Application number: 2023/90596	
What is the application for?:	Erection of 2 business units and associated service yard (E(g) iii)
Address of the site or building:	Land opposite Orchard Works, Spen Vale Street, Heckmondwike, WF16 0NQ
Postcode:	WF5 9NQ

Block Plan 1: 500

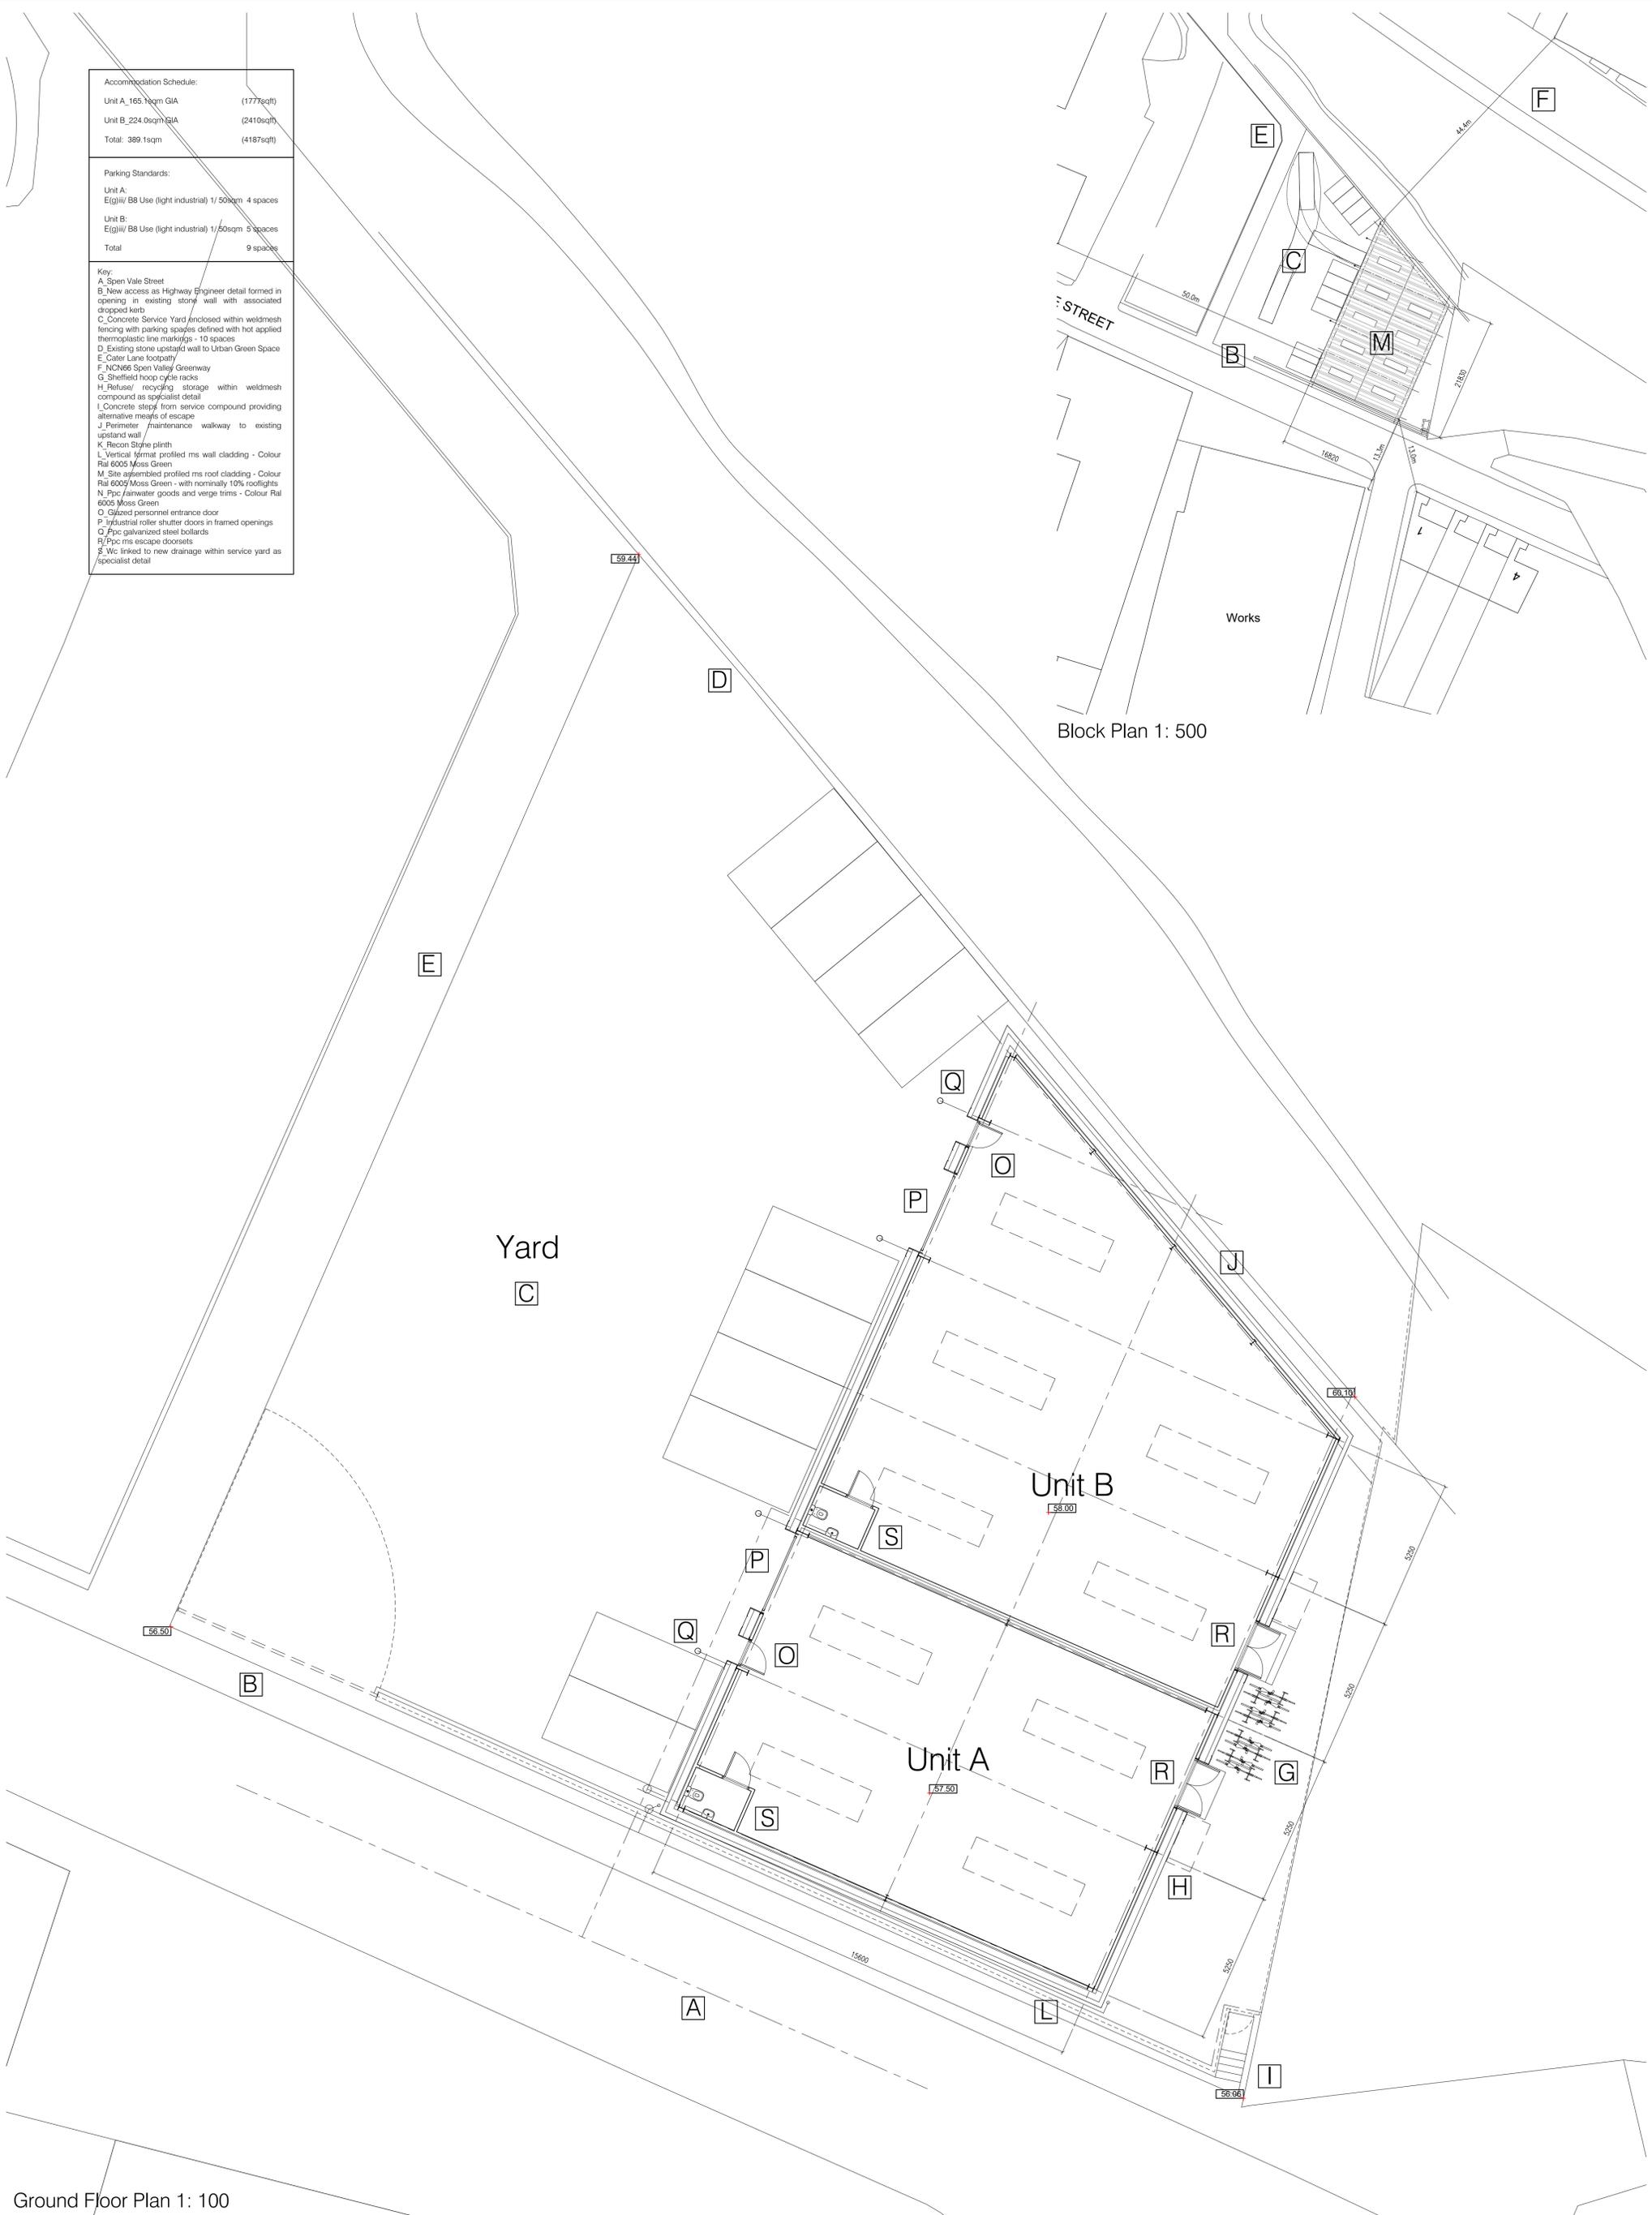
Type of comment: A general comment	
Do you wish your comments to be published on the website anonymously?	<input type="checkbox"/> Yes
My main comment would be the vehicle access to the proposed new site is right next to the entrance/exit for the greenway this could be very dangerous for dog walkers, bike riders etc. As I live in the house closest to the proposed works I hope that the work takes place during the day 8am-5pm Mon - Fri. The mud that the work will create will cover the road I hope the work people clean up after all the excavators have been.
